CITY & COUNTY OF SWANSEA

Fifth Deadline Comments

Abergelli Power Project

PINS REFERENCE: EN010069

Illustrative Elevation of Road Structure Over Utilities

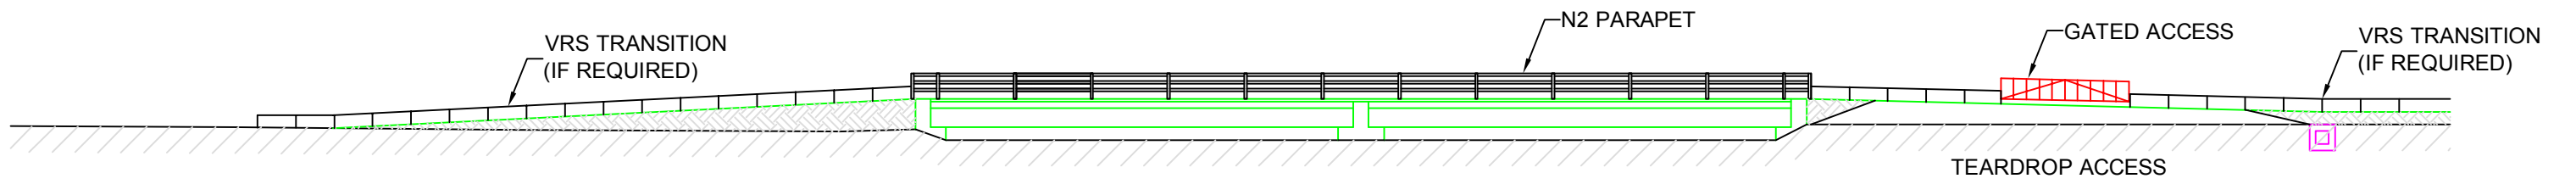
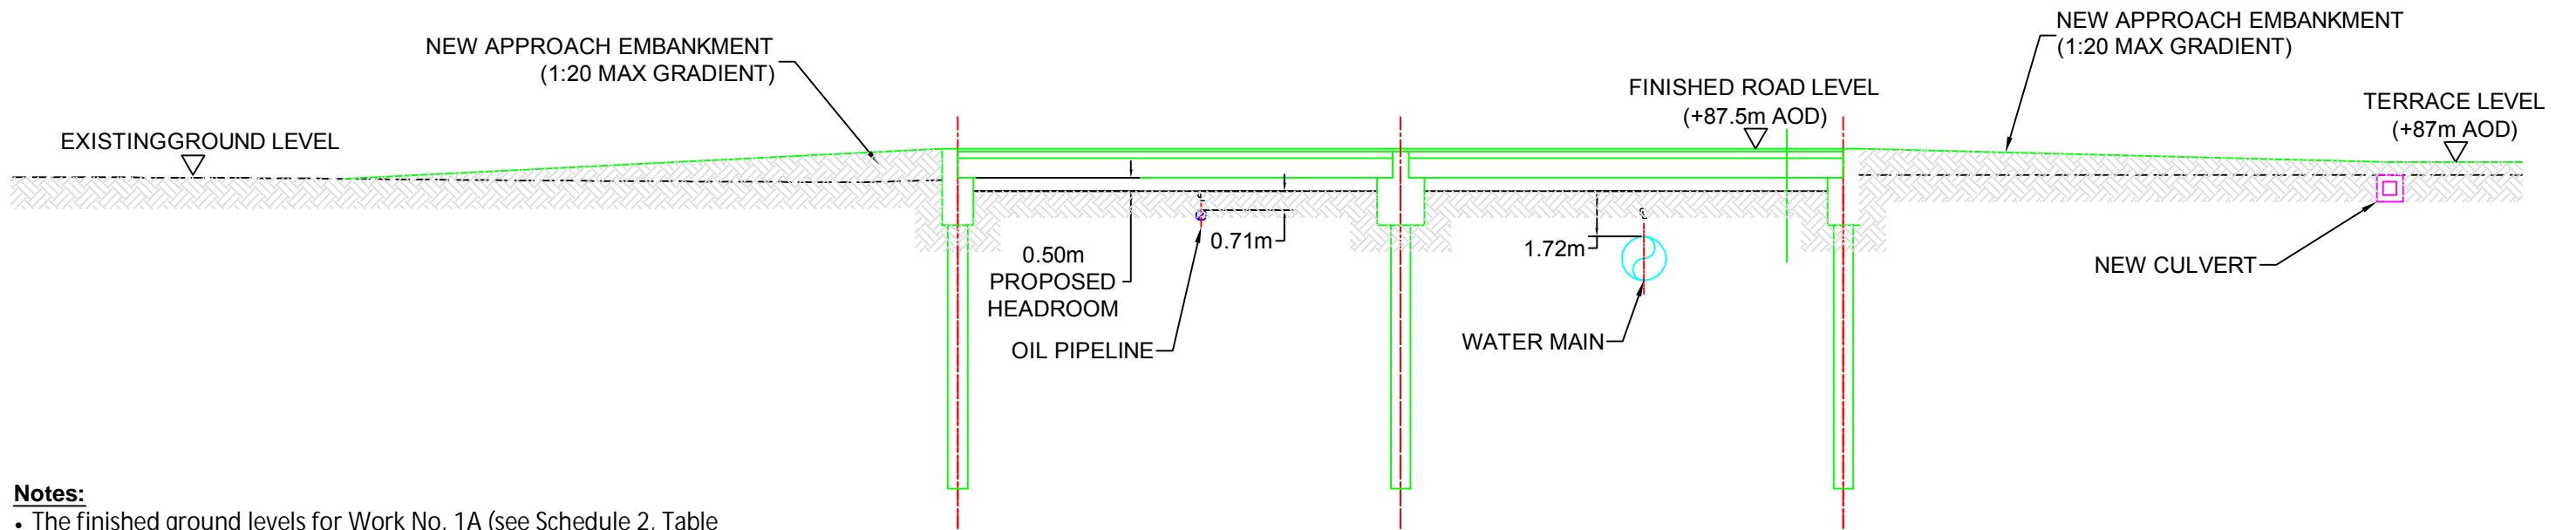
CCS has no issues with the parameters identified for the road structure over the water main but would query whether the maximum height of the structure includes the 1.2m safety barrier or not. It is assumed that it won't but the safety barrier would form part of the “structure” as defined in Table 3.

This isn't a significant issue as far as CCS is concerned but clarification is sought as to whether the 5m maximum height includes or excludes the 1.2m rail from the outset.

CCS would also suggest that it needs to be specifically included within the definition of Work No. 2 in Schedule 1.

CCS welcomes the submission of the Illustrative Elevation and has no issues with regards to the indicative design.
